KIRKLEES METROPOLITAN COUNCIL INVESTMENT & REGENERATION SERVICE

DELEGATED DECISION TO DETERMINE APPLICATIONS FOR NON-MATERIAL AMENDMENTS

Reference No: **2024/NM/92974/W**

Site Address: Greenhead College, Greenhead Road, Huddersfield,
HD1 4ES

G - Courtyard Infill - North Elevation
1:100

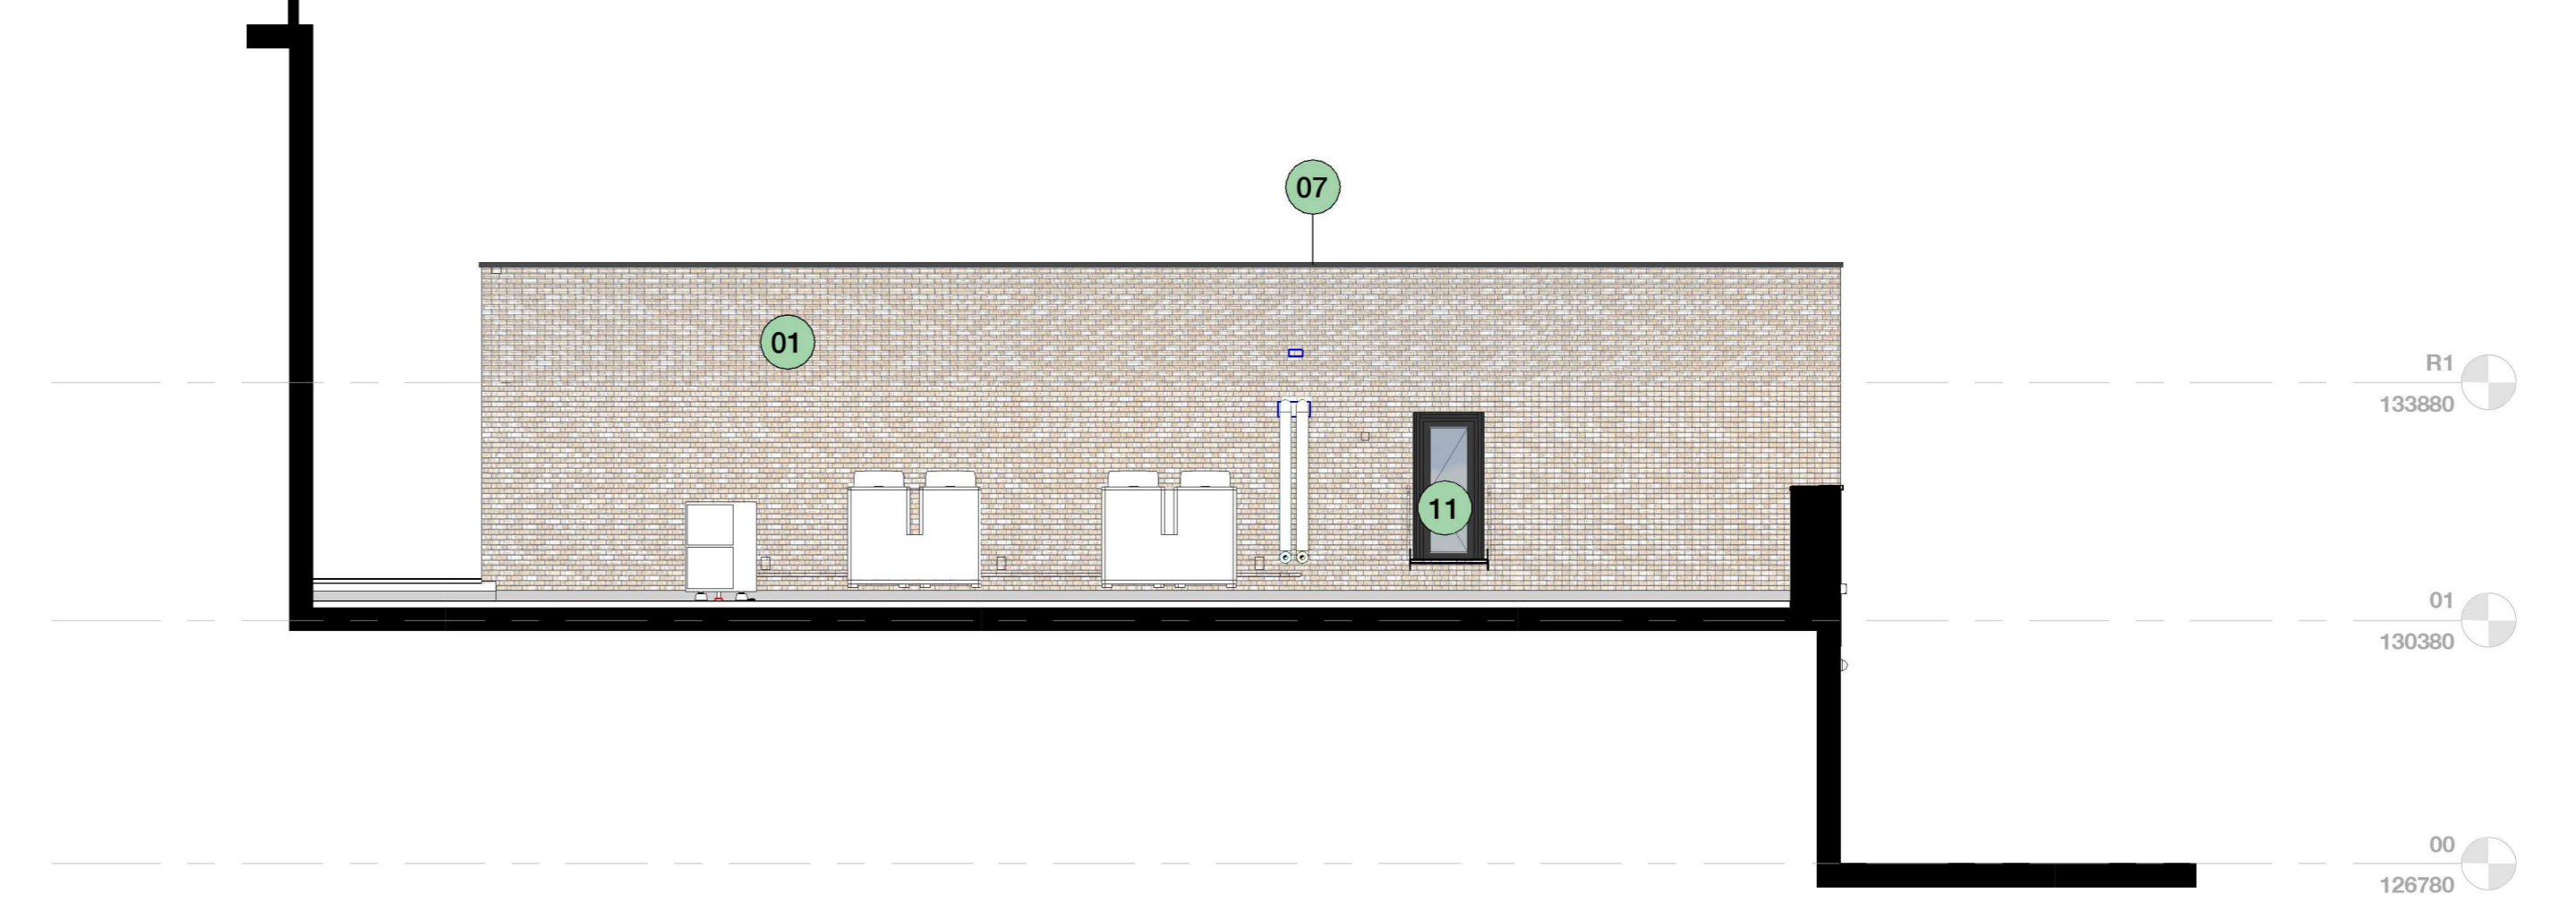
- *Additional duct work through roof to align with developed MEP design – the ductwork will not extend above the parapet.*
- *Revised configuration of air source heat pumps (ASHPs) and related services to gutter line to suit developed MEP design.*

- *New air handling units (AHUs) located on the roof of the new building due to a client instruction to replace existing end-of-life units. The new units and ductwork will not extend above the parapet so will be visually screened. This results in the incorporation of the existing pitched roof into the new building parapet.*

- *Existing sloping parapet extended to create a flat top to guard roof edge and conceal AHU and ductwork from view.*
- *Updates to indicate surveyed existing building lines and retained building footprint.*
